DRB Application No.: 07DRB-70215 (SBP)
Project Name: L'IL SQUIRRELS PRESCHOOL
Agent: GARLAN BRYAN ARCHITECT

3. Project# 1006780
07DRB-70215 MAJOR - SDP FOR BUILDING PERMIT

3. Project# 1006780
07DRB-70215 MAJOR - SDP FOR BUILDING PERMIT

GARLAN BRYAN ARCHITECT agent(s) for MATT PADILLA request(s) the above action(s) for all or a portion of Lot(s) 5, **JOURNAL CENTER PHASE 2, UNIT 1, L'IL SQUIRRELS PRESCHOOL**, zoned IP, located on HANCOCK CT NE BETWEEN WILCOTT AVE NE AND HAWKINS NE containing approximately 0.5016 acre(s). (D-17)

WEST ELEVATION

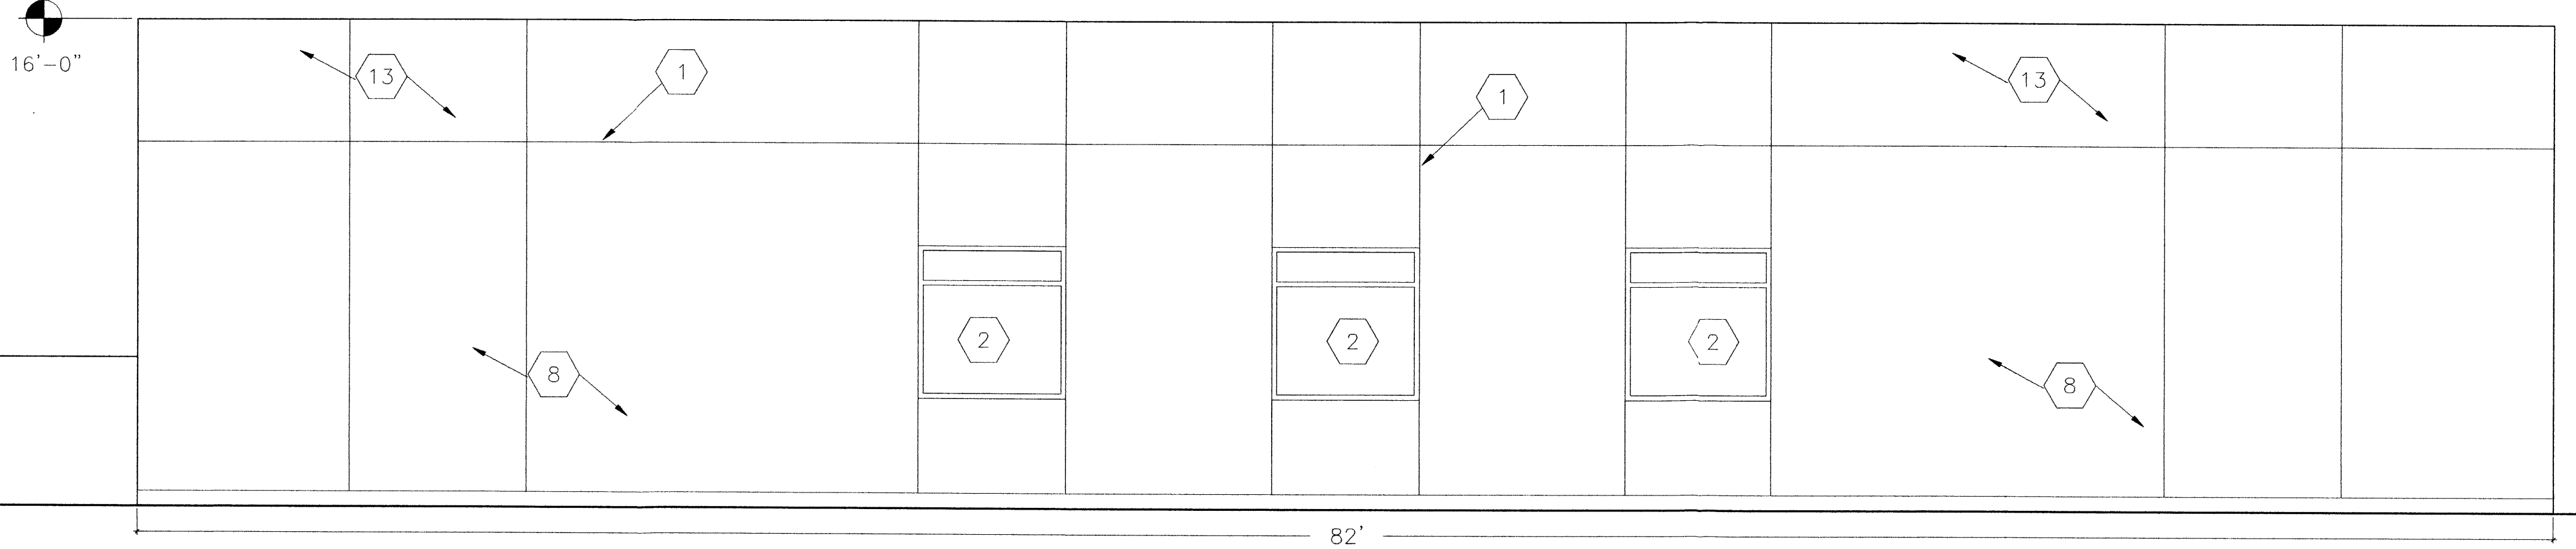
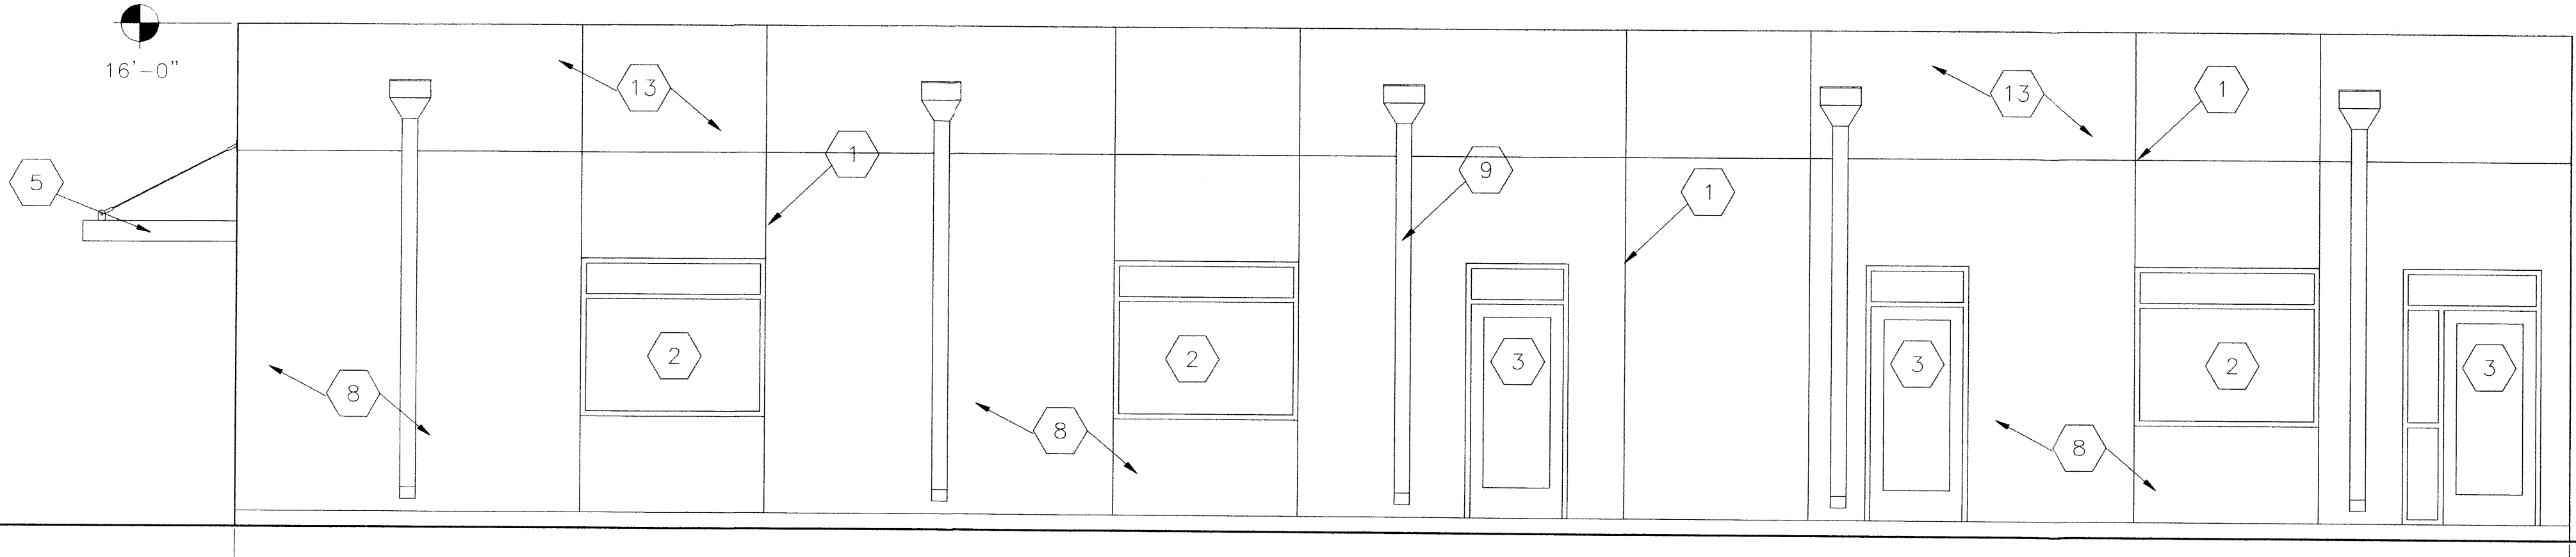
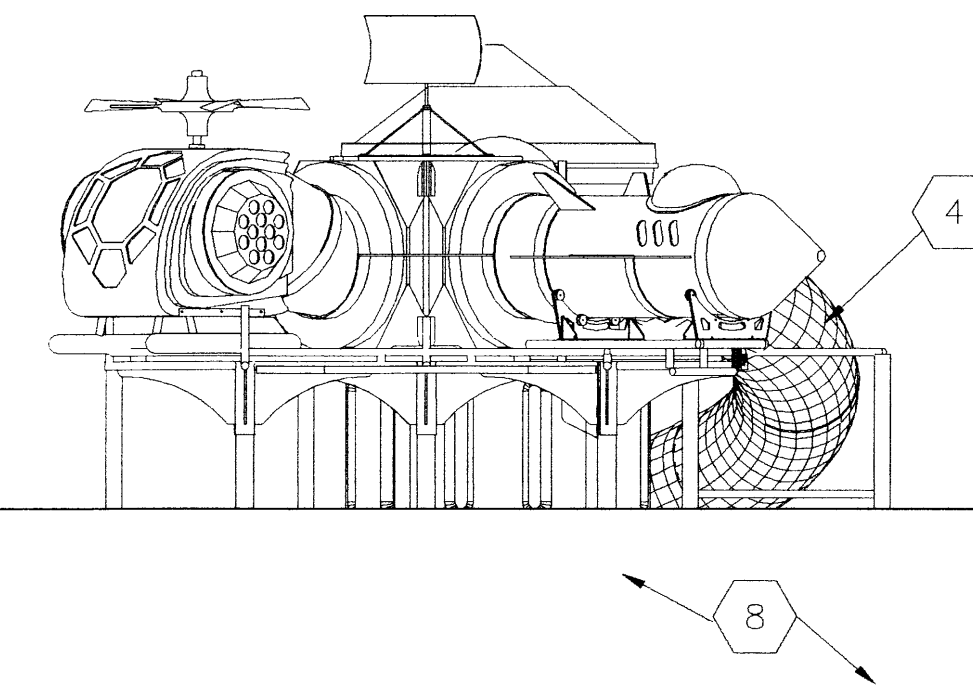
- 7. Santa Fe Brown gravel is required to a minimum depth of 3 inches. Indicate in the note on the Landscape Plan.
- 8. The building elevation sheet is very sparse in details, including specific colors.
